# **Lime Down Solar Park**

**Planning Inspectorate Reference:  
EN010168**

**Wiltshire Council Written Representation**

**May 2026**

Drawing file: published-documents / EN010168-000768-6.2 Figure 13-11 Construction Access Locations Solar PV Sites.pdf

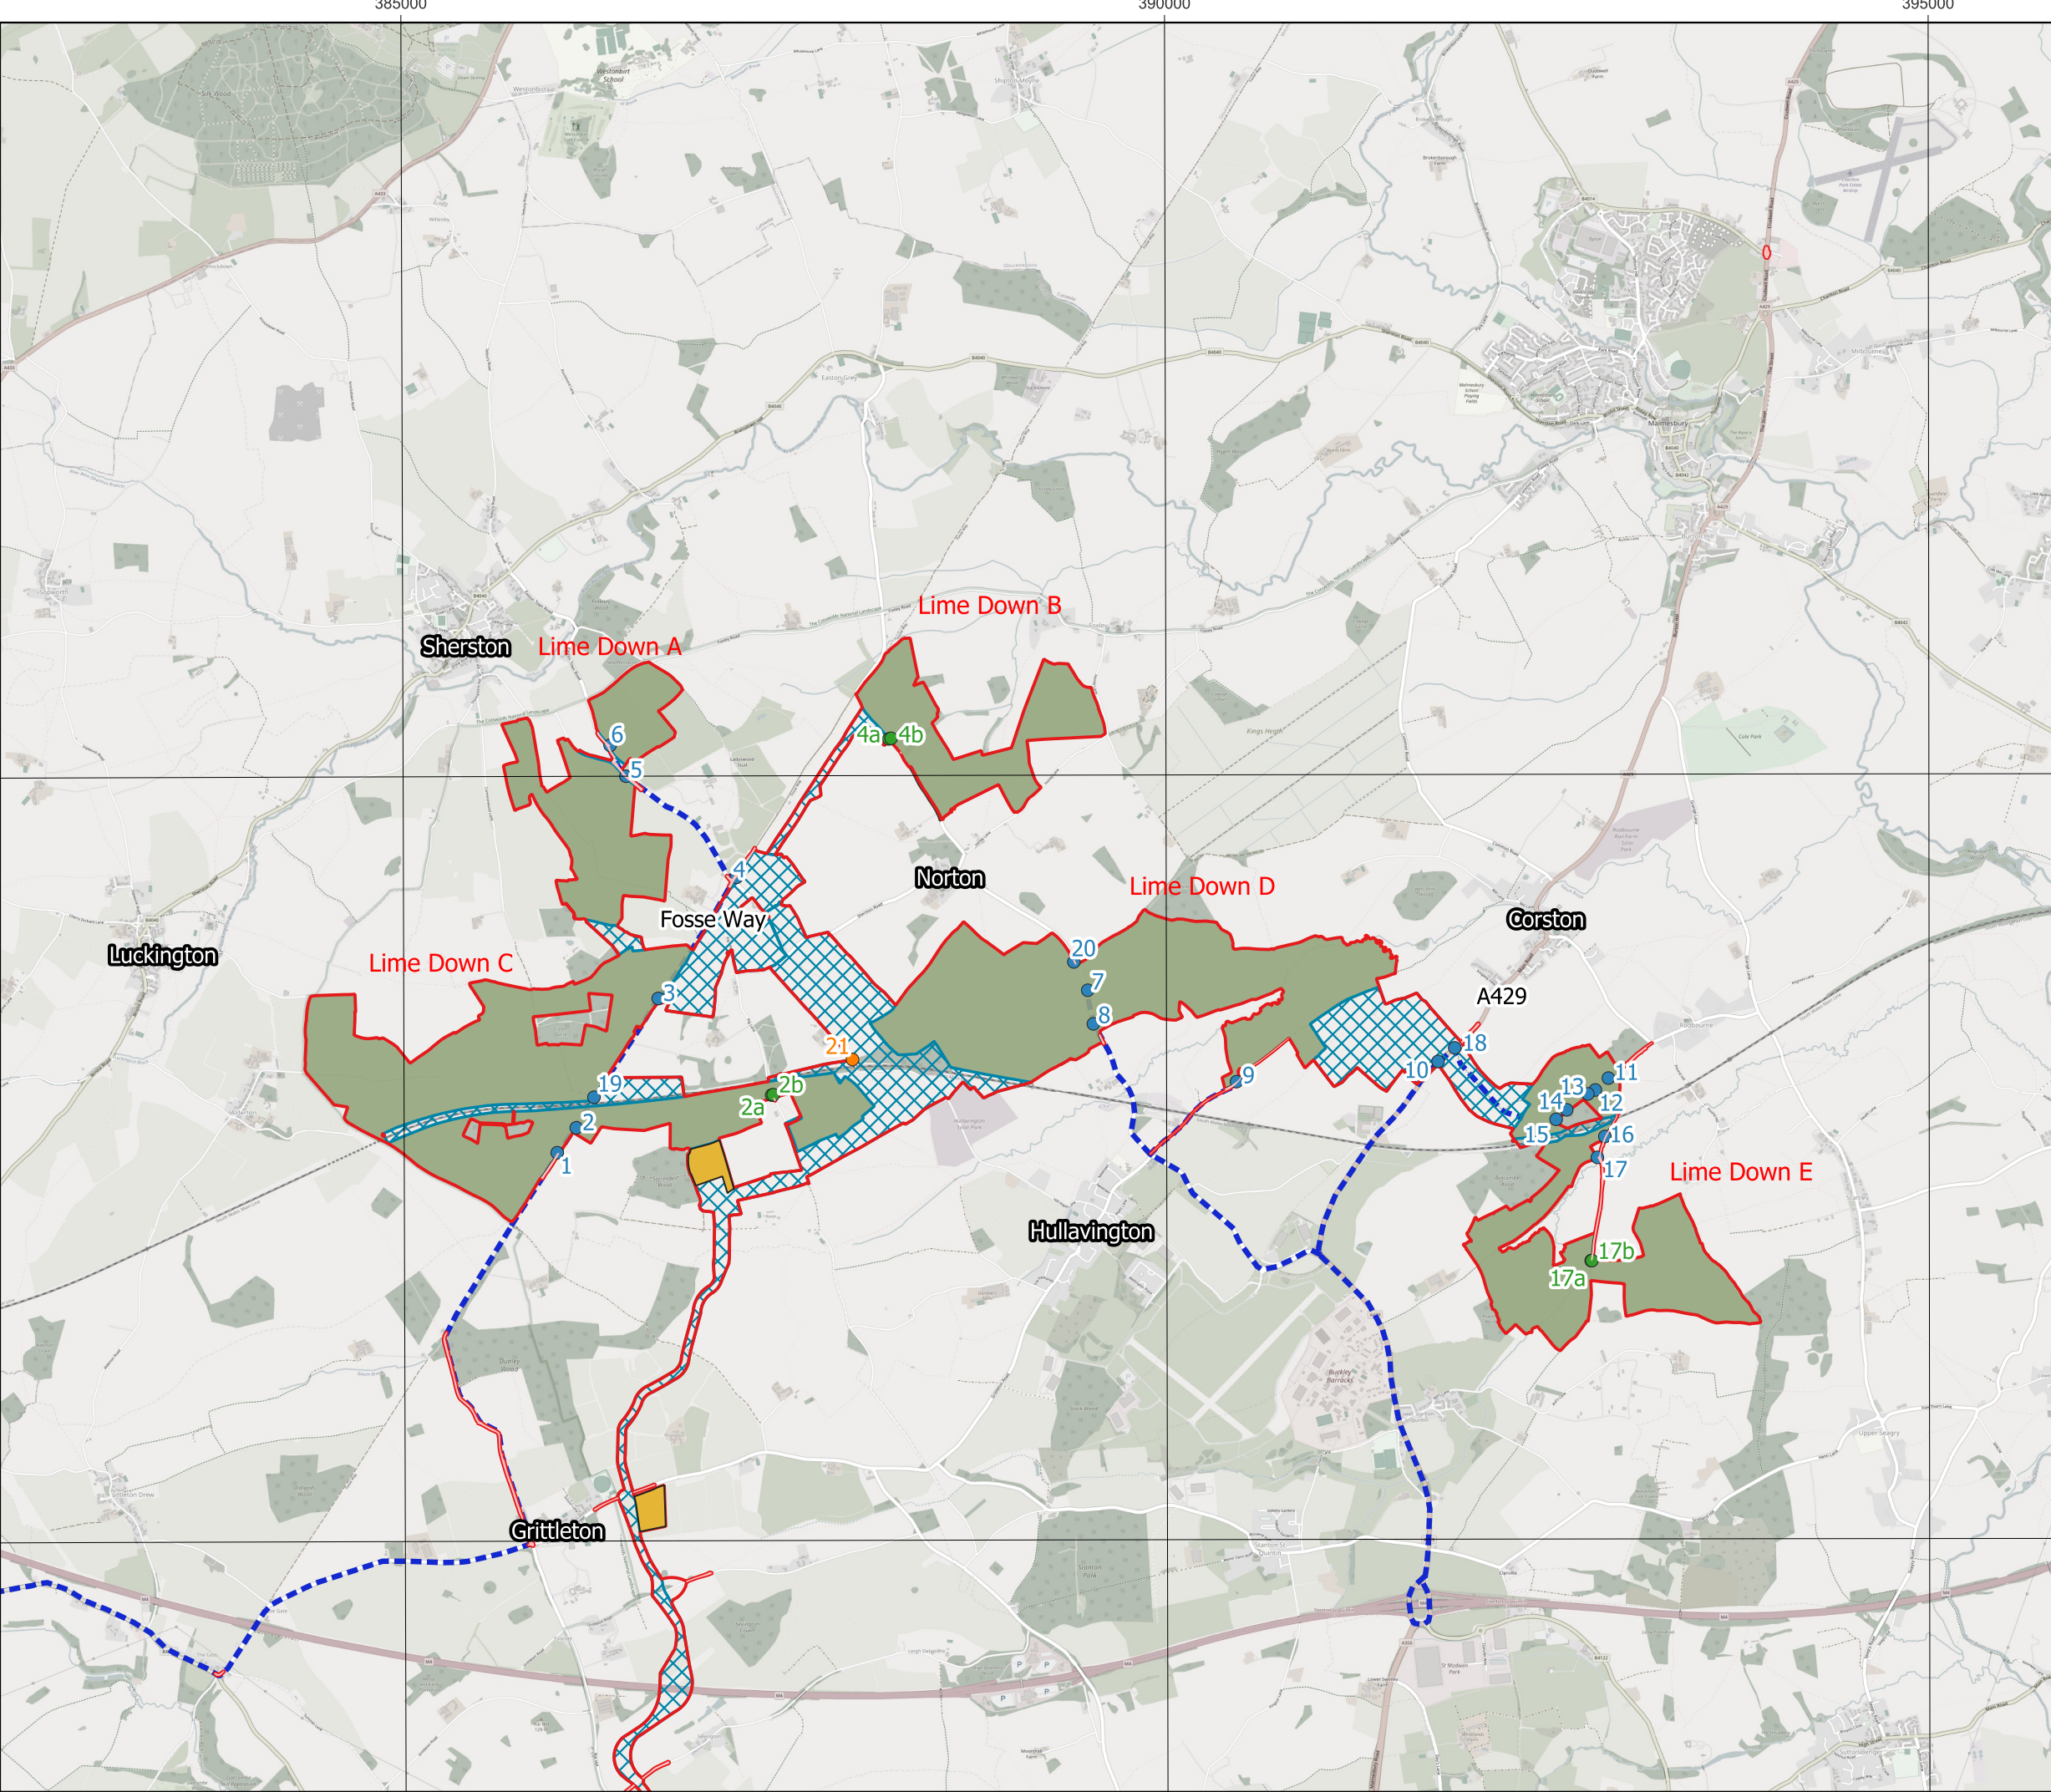
- 5.6. Key issues which have not been adequately addressed:
- Creation of 5 number major access points to construct Lime Down Solar Park areas A, B and C, taken off the Fosse Way as illustrated by 6.2 Environmental Statement Volume 2, Figure 13-11 Construction Access Locations: Solar PV Sites [\[APP-156\]](#), and use of 5 number access points taken off the Fosse Way for ongoing maintenance as illustrated by 6.2 Environmental Statement Volume 2, Figure 3-4-3.1 (Site C Sheet 1), Landscape and Ecology Mitigation Plan [\[APP-084\]](#), allowing uninterrupted views of solar development and infrastructure.

- Increased traffic flows along the Fosse Way during construction, operation and decommissioning, resulting in a loss of tranquillity and additional visual intrusion.

- An accurate plan of vehicular movements affecting the Fosse Way route through the duration of the project will be required.
- Where long-term maintenance access is necessary from the Fosse Way, the planting of a secondary hedge inside the access points, although not ideal from a landscape character point of view, would restrict receptor views of the developed field parcels when passing the access points.
